21 June 2021

Tweed Shire Council comments on the EIS for the proposed upgrade and expansion of Kingscliff High School to provide new permanent teaching spaces and core facilities including a new creative and performing arts building and associated amenities, senior learning spaces, refurbished hospitality facilities and learning areas and refurbished general learning spaces (SSD-8744305) at Lot 3 DP 803772; Cudgen Road KINGSCLIFF; Lot 57 DP 803814; No. 33 Oxford Street KINGSCLIFF

Reference is made in regards to the above proposal and the Department's request for Council's advice/comment on the Environmental Impact Statement. Council officers have undertaken a review of the proponent's EIS and supporting documentation and provide the following comments for the Department's consideration.

**SITE PLAN - EXISTING & DEMOLITION -
GROUND**

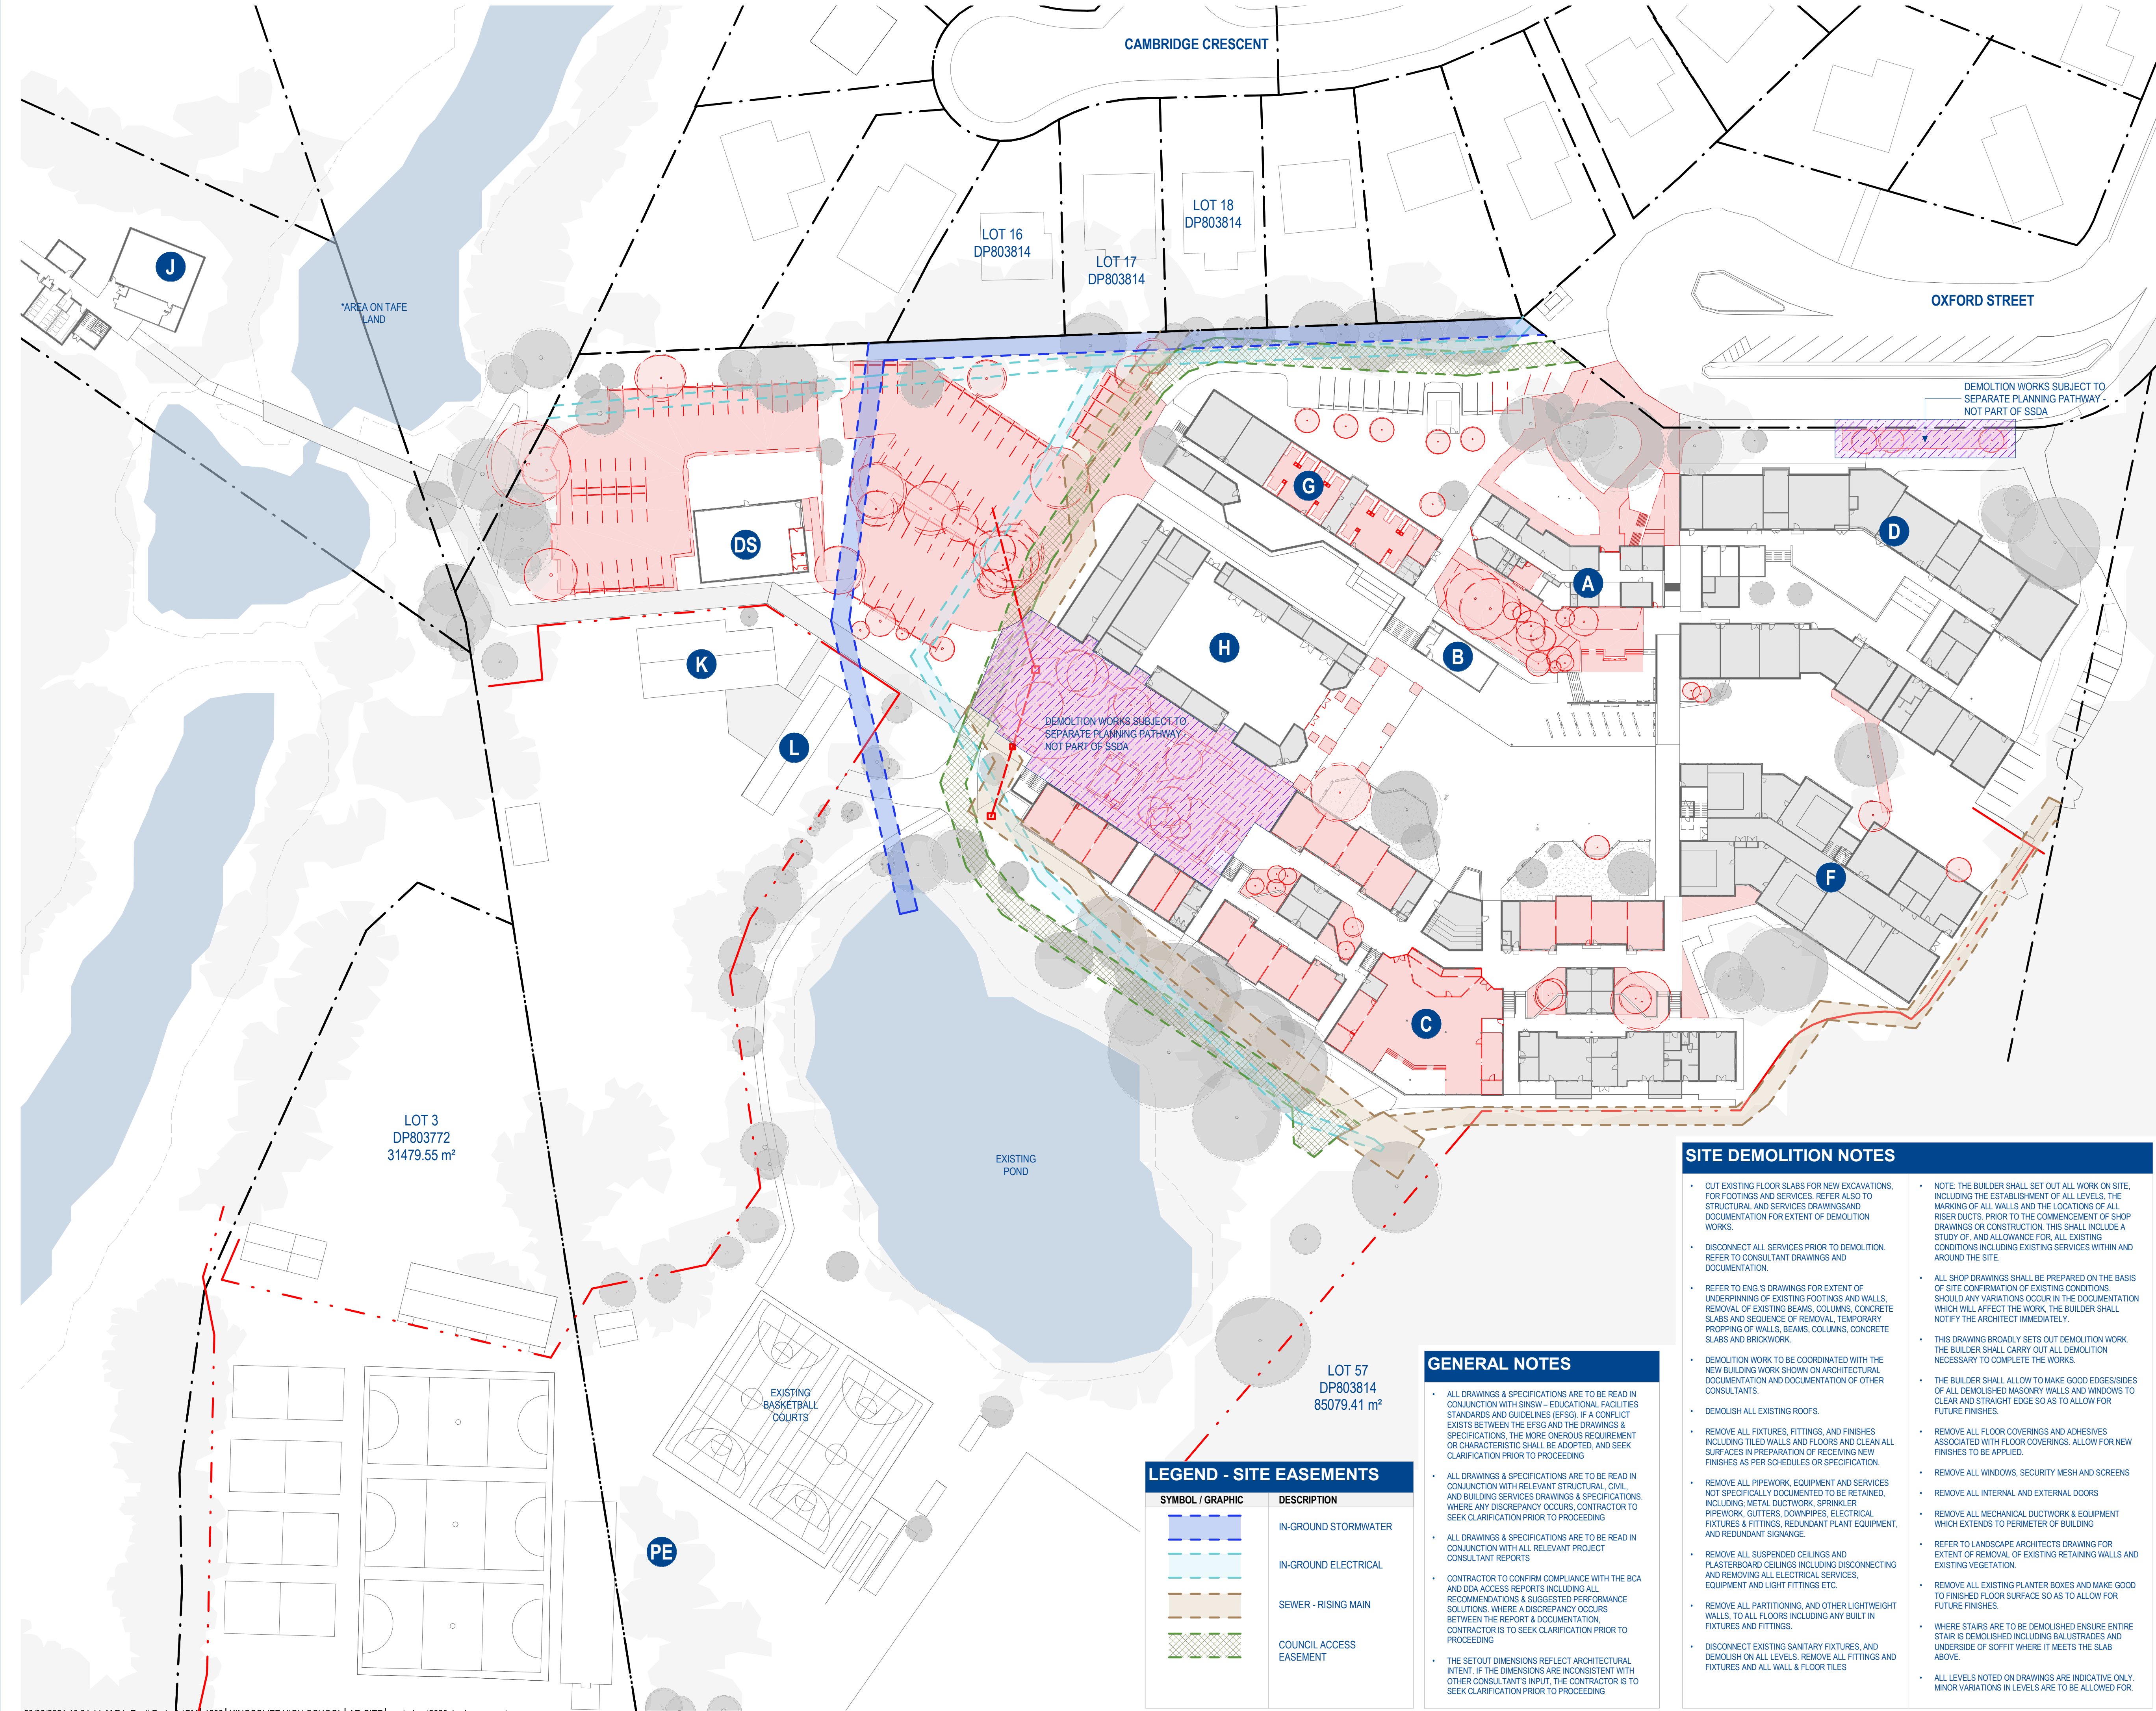
The location of buildings over existing stormwater infrastructure is not supported. Existing stormwater infrastructure is to be moved away from the building footprints and relocated in a new 3m wide easement. Council's Development Design Specification D15 – Works in Proximity is to be considered in relation to the proposed building footings and relocation of the stormwater pipe and pits.

- a) The existing stormwater line shown under the 'Dance Studio' building is to be relocated away from the building footprint. Engineering details are to be provided of the relocated stormwater pipe within a new 3m wide easement.
- b) The 'potential existing stormwater pipe' shown under the proposed 'Creative & Performance Art' building is to be relocated away from the building footprint. Accurate survey detail is to be provided to determine the location of the existing stormwater pipe and pits. Engineering details are to be provided to show the relocated stormwater pipe within a new 3m wide easement.

6.2.3 It appears that a building is proposed over Councils gravity sewer pipeline, which shall not be permitted by TSC. However, it is noted that a recent Section 68 application has been received that proposes to relocate a section of the gravity network within the lot (from MH A/1B to MH A/2) to facilitate the development. Please make note of this in the Utilities Infrastructure Report and show the existing and proposed alignment on the Architectural and Civil Plans.
